Subject: RE: BR/256/19/PL

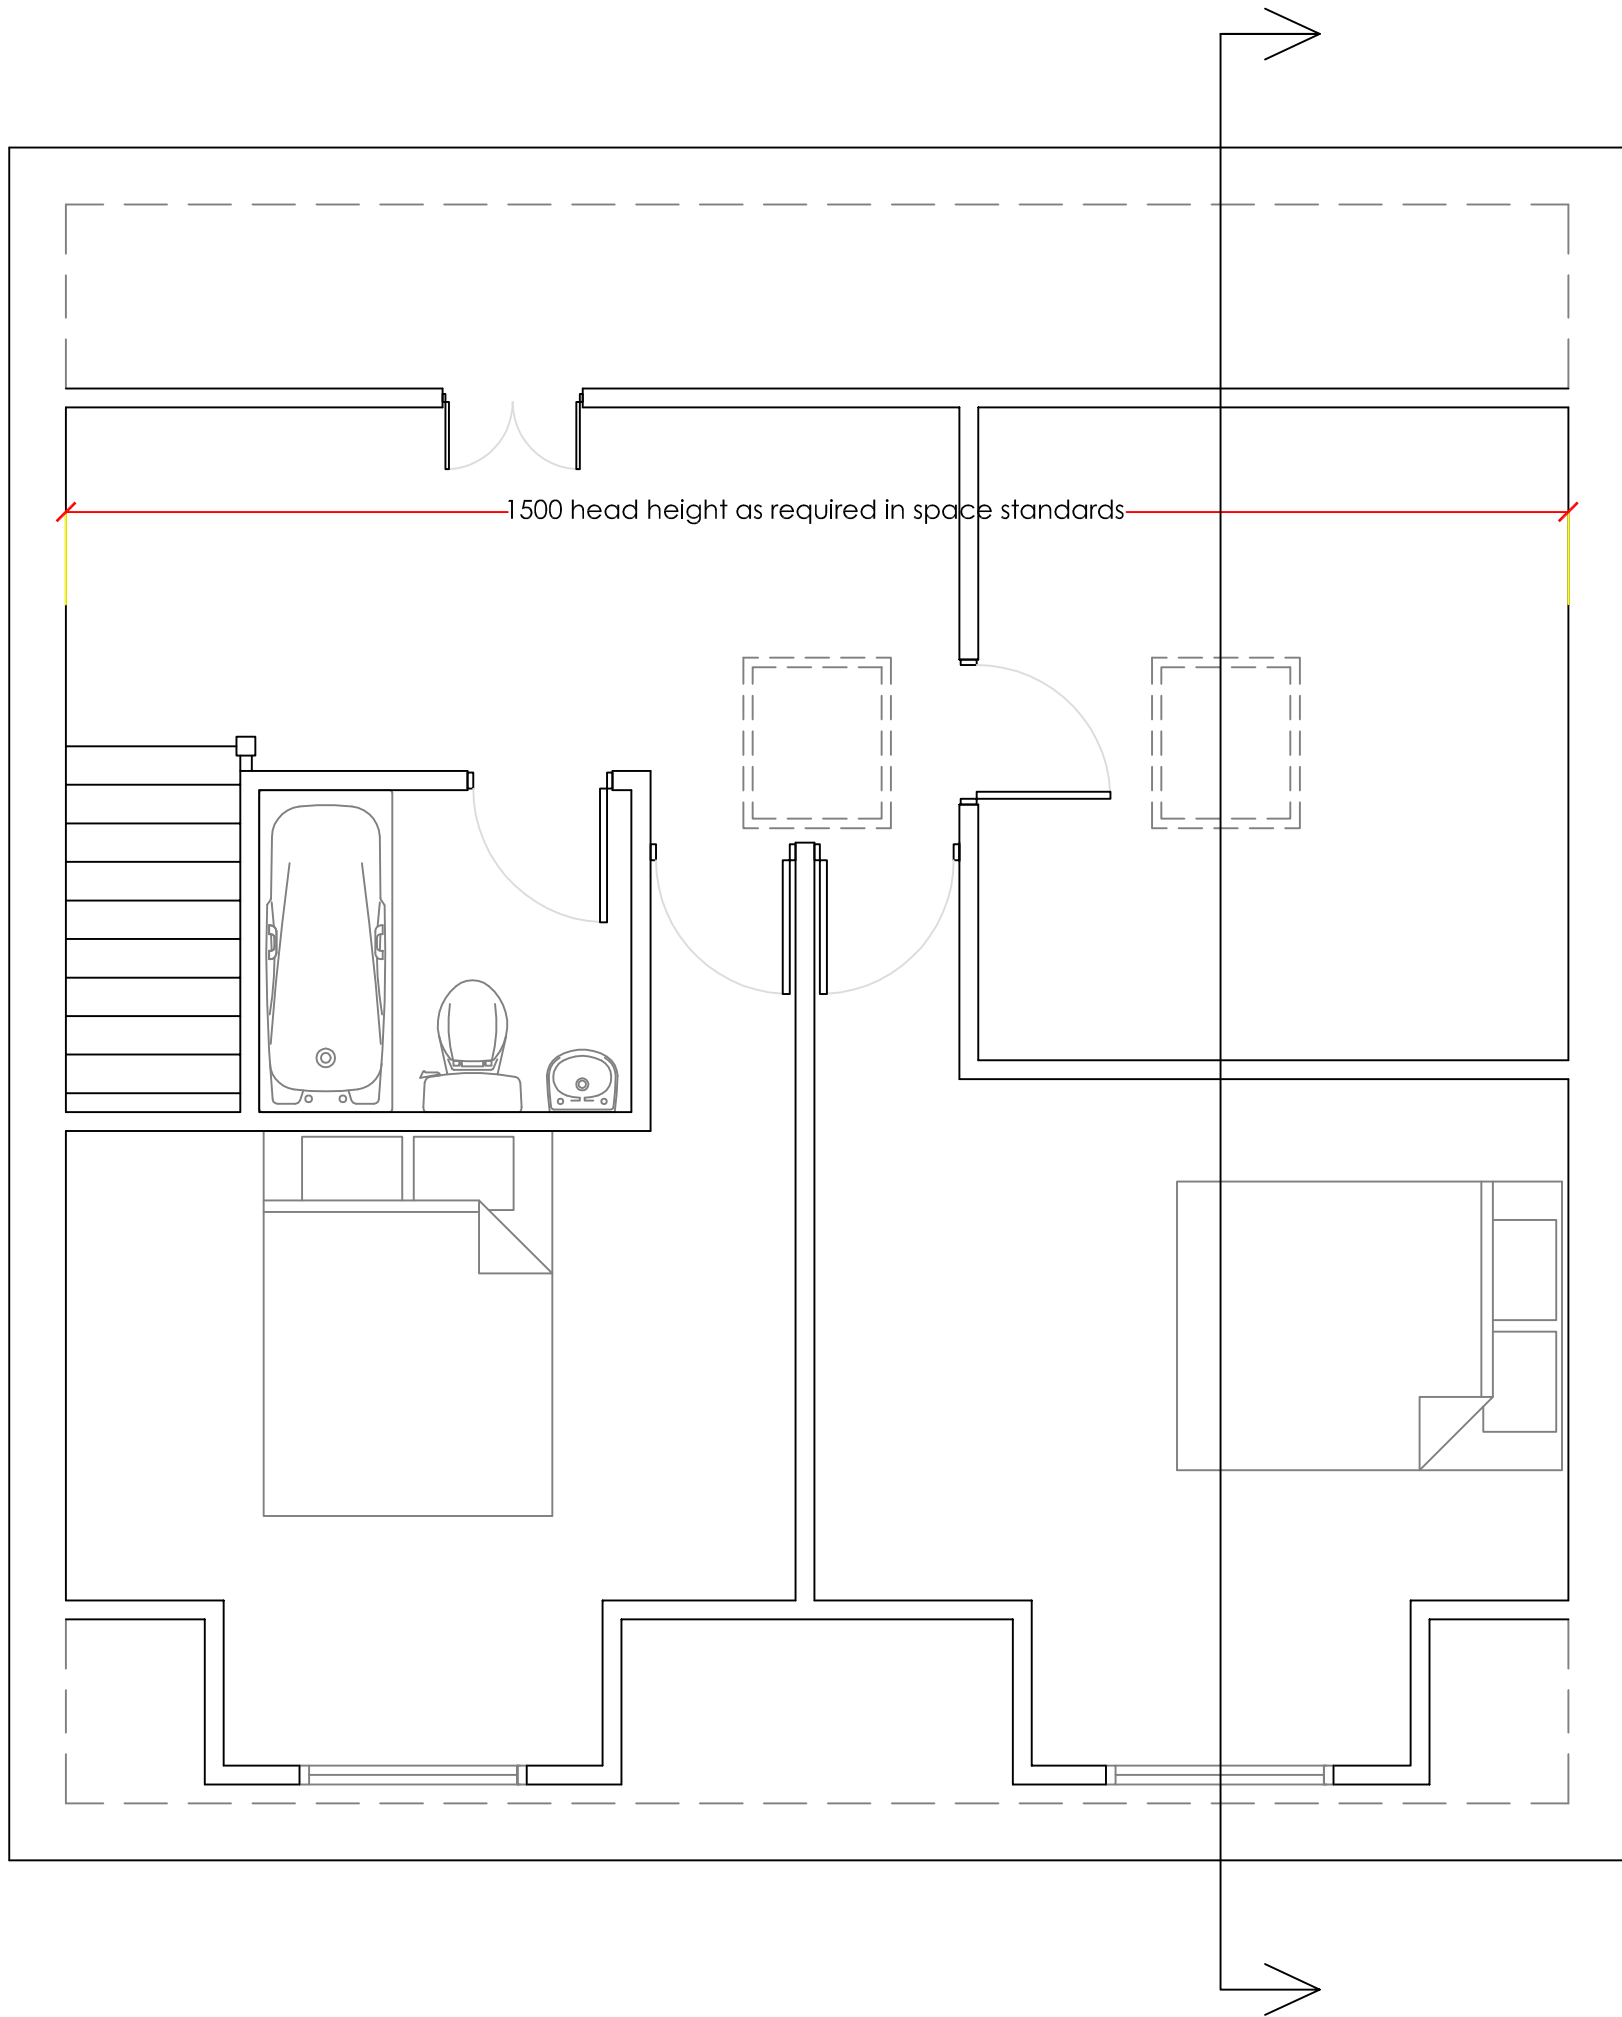
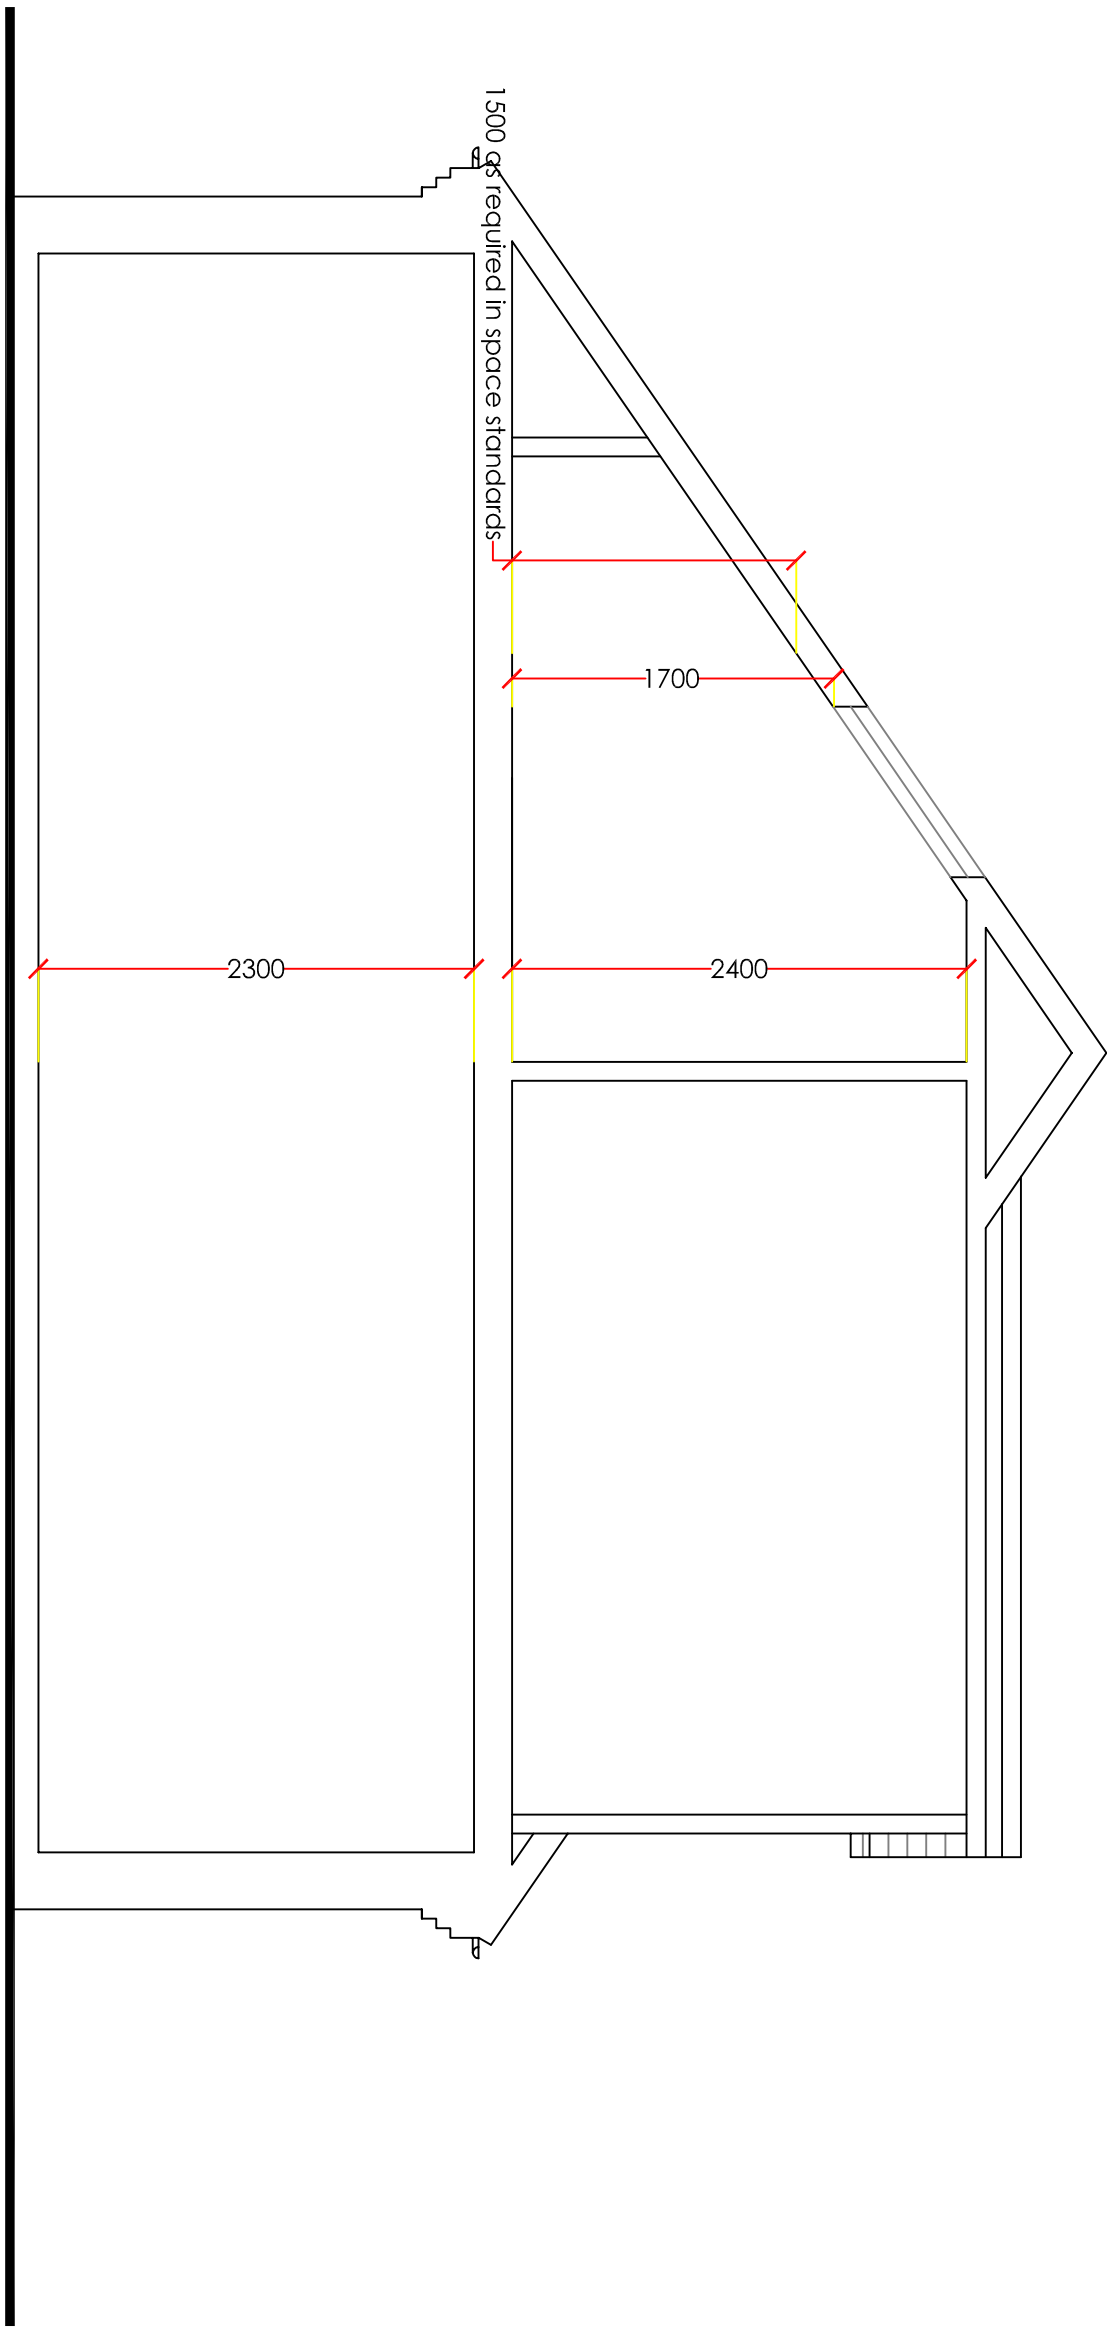
- 1) Could you provide an internal section to show how the pitch of the roof impacts upon internal spaces in the rooms to the rear? I envisage significant concern will be raised given that what is in effect a bedroom is shown to the rear. I will obviously need to assess this as such against internal space standards etc. I also need to be satisfied, through the submission of a section, to ensure the velux rooflights are 1.7m above FFL to overcome issues of overlooking etc...

I note that Simon has requested internal sections of the building to satisfy concerns relating to internal heights – I would be grateful if these could be provided as soon as possible?
